**RE: Application by Rampion Extension Development Limited for an Order Granting Development Consent for the Rampion 2 Offshore Windfarm Project**

**Horsham District Council Deadline 5 Submission**

## **EN010117: Application by Rampion Extension Limited for the Rampion 2 Offshore Wind Farm**

HDC Response to the Applicant's additional information/submissions received Deadline 4.

**Key to Phasing of Planting**

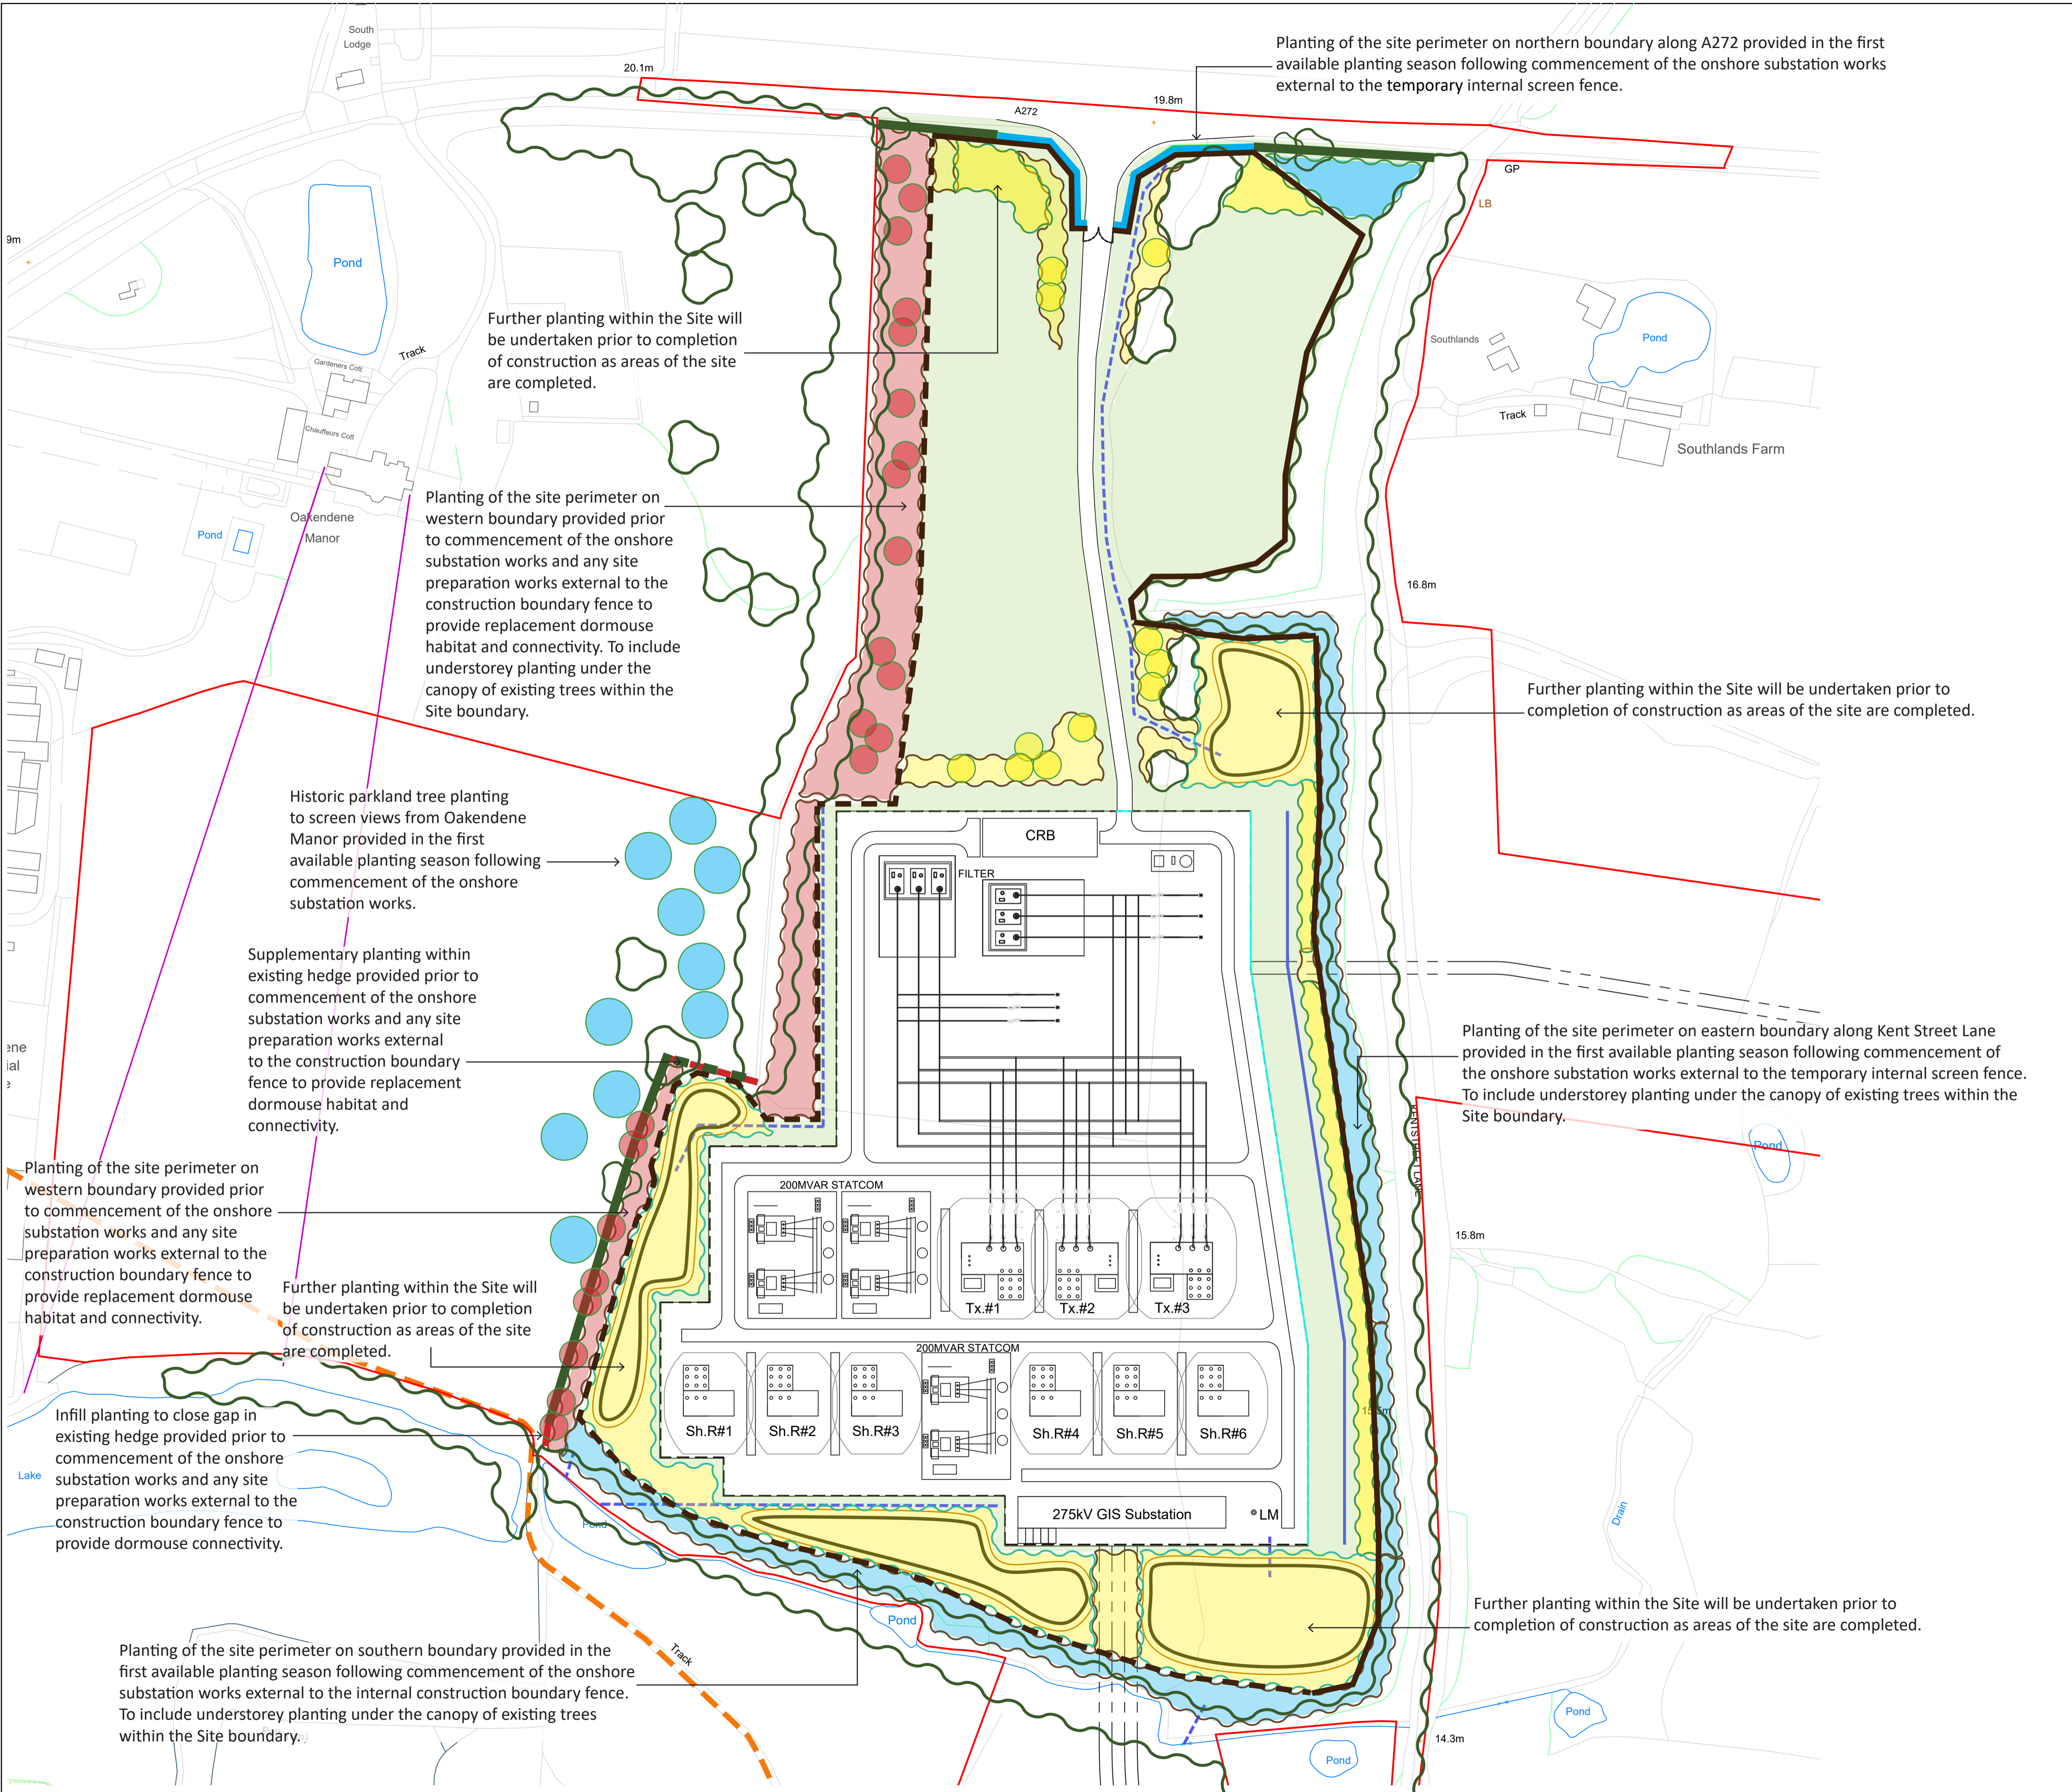
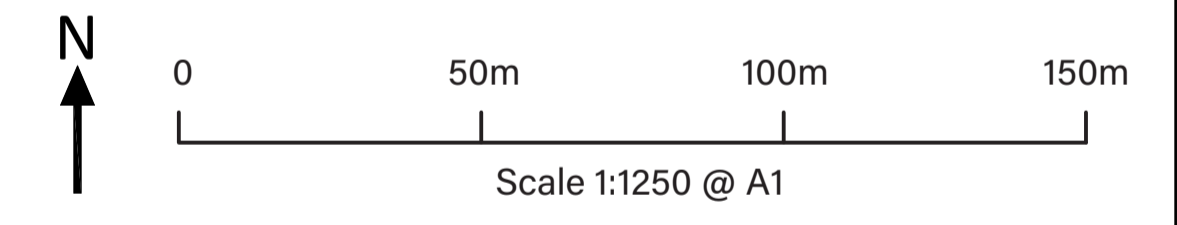
<p>HDC has concerns with the removal and absence of assessment of this loss on the character and visual amenity of Kent Street. We await provision at Deadline 6 but in the meantime register HDC's concern.</p>
<p><b>[REP4-048] Outline Landscape and Ecology Management Plan REV C</b></p>		<p>HDC refers to Oakendene Substation Indicative planting phasing plan 42285-WSPE-EX-ON-FG-OL-3902 which it is noted is not listed in the List of Figures in the Contents of the OLEMP REV C [REP4-047]. Several drawings submitted at the back of the OLEMP are not included in the List of Figures, please update.</p> <p>HDC notes from the Indicative planting phase plan that the planting area denoted in the colour blue with the key to Phasing of Planting referring to 'first available planting season following commencement of the onshore substation works', includes areas to be planted beyond the site's temporary perimeter fencing (described in various ways as internal screen fence to eastern boundary/ internal construction fence to southern boundary/construction boundary fence to western boundary/temporary internal screen fence to northern boundary).</p> <p>One of the first tasks to be carried out when setting up a construction site is to erect the perimeter fencing to make a site secure (it is assumed that this is the fencing that is being referred to in differing ways on the plan and clarification on this is requested with the wording of the plan amended). Planting the area denoted in blue after the fence is erected is not practical and likely to result in poor delivery, longer planting times as access will be partially constrained and limited for maintenance purpose only.</p> <p>Assuming all references on the planting phase plan relate to the same perimeter fencing, it is understood the western boundary is to be planted prior to commencement of the onshore substation works which will have to take place within the appropriate planting season. All areas identified in blue, save for the formation of the site access, are adjacent to existing vegetation and no ground</p>

<p>works are to take place other than planting and the erection of the perimeter fencing therefore, the need to leave the area to be planted until the first planting season available is queried. It is recommended that these areas also come forward as advance planting and the wording on the Indicative planting phasing plan 42285-WSPE-EX-ON-FG-OL-3902 updated to reflect this.</p> <p>HDC recommended wording as follows:  <i>'First available planting season prior to the erection of perimeter fencing'</i>.</p> <p>It is also recommended that the key includes the following wording:  <i>Temporary close board fence to have access points suitable for maintenance of the landscaped areas.</i></p> <p>These necessary amendments to the indicative planting phasing plan 42285-WSPE-EX-ON-FG-OL-3902 would satisfy HDC that the buffer zones, which are a key mitigation to the LVIA assessed mitigation strategy is delivered in a timely manner and maintained successfully.</p> <p>Alongside amendment to the phasing plan, HDC strongly supports item 8 of ExA's Proposed changes to the draft DCO which has recommended provision of an overarching site-specific plan for Oakendene prior to works commencement, to address, amongst other things, HDC's ongoing concerns regarding feasibility on habitat creation and its establishment and long-term survival (whether this is wet or dry woodland), and demonstrating how drainage will work with landscaping to deliver the necessary mitigation.</p>
